Application No: AB/98/21/HH  
Site Address: 4 High Ridge Close Arundel BN18 9ES  
Description of works: Erection of 2No single storey rear extensions. Conversion of roof space to habitable use to include 2No front and 1No rear flat roof dormers. Increased width of existing vehicular crossover and 1No additional crossover. Gabled canopy to front entrance and removal of chimney.

Thank you for your internet representation made on 29th August 2021 which has been recorded as an objection with the comments as follows:

Roof space plan 1:100 @ A3

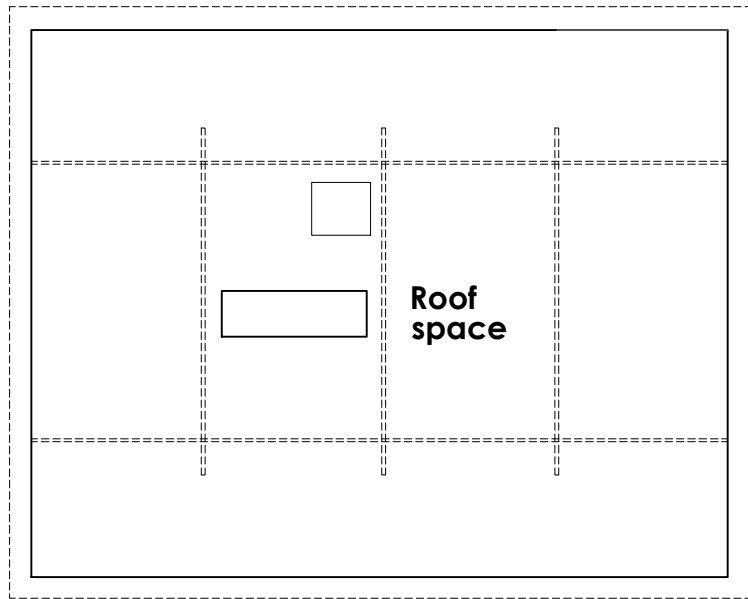
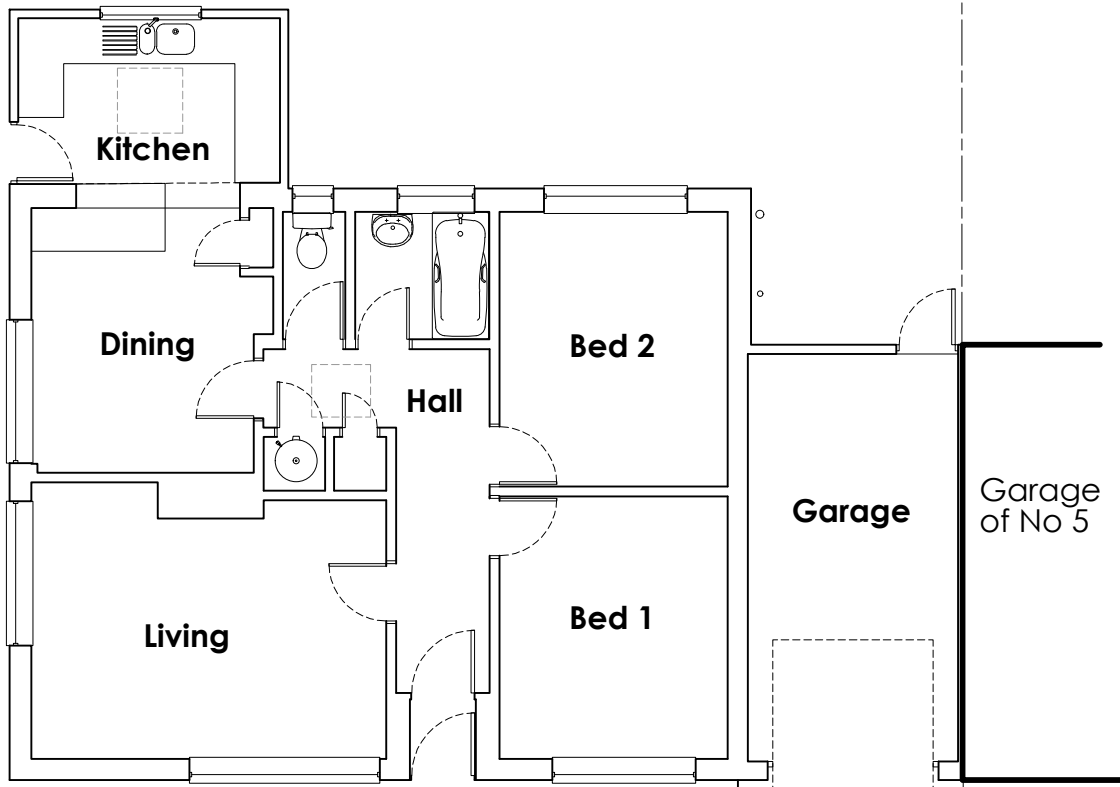
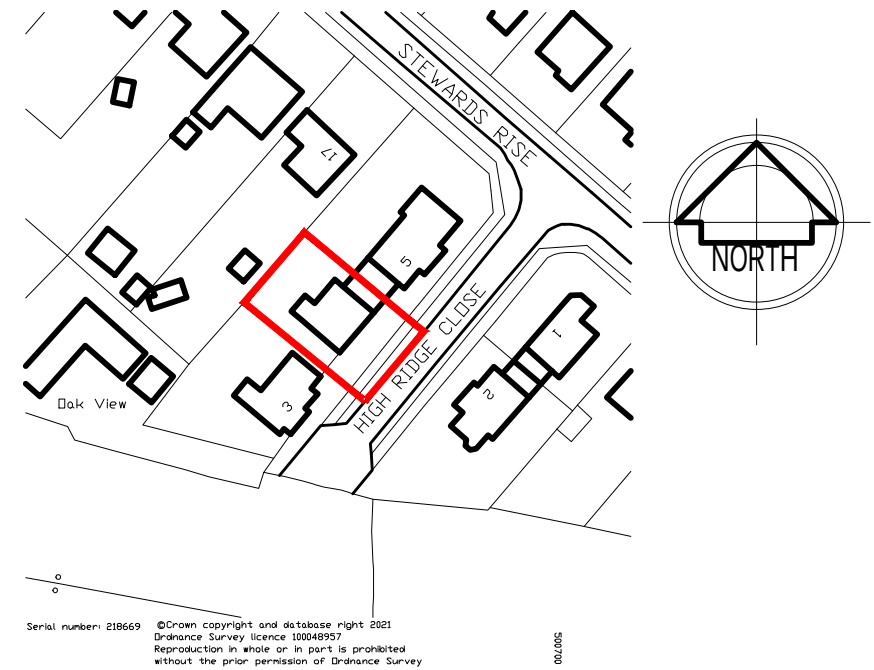
The proposed flat roof dormers to the front of the property would be inconsistent with the other houses in the close and would look directly into the two houses across the road.

The balcony - it is unclear from the application exactly what sort of balcony is proposed. If it is to allow access to the roof, this would provide direct and unobstructed visibility into the gardens of No3 and No 5 and would be unacceptable.

Block & Site plan 1:200 @ A3

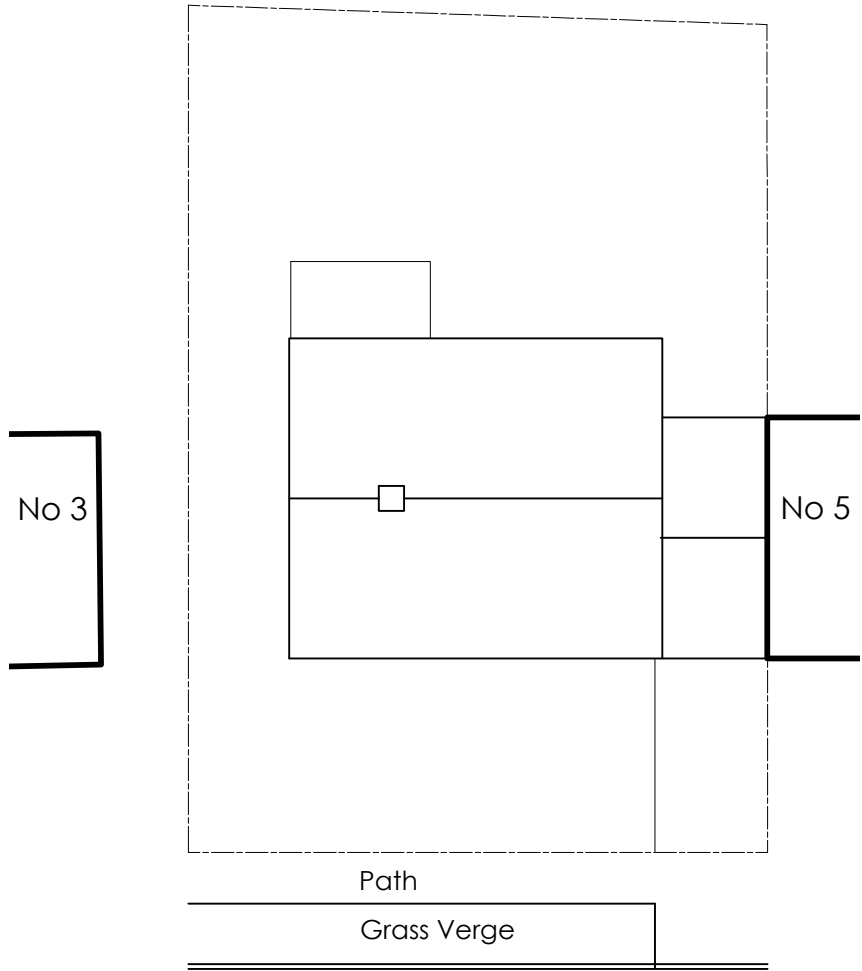
Many allotment users park their cars in High Ridge Close and dropping the kerb to No4 would restrict their ability to park.
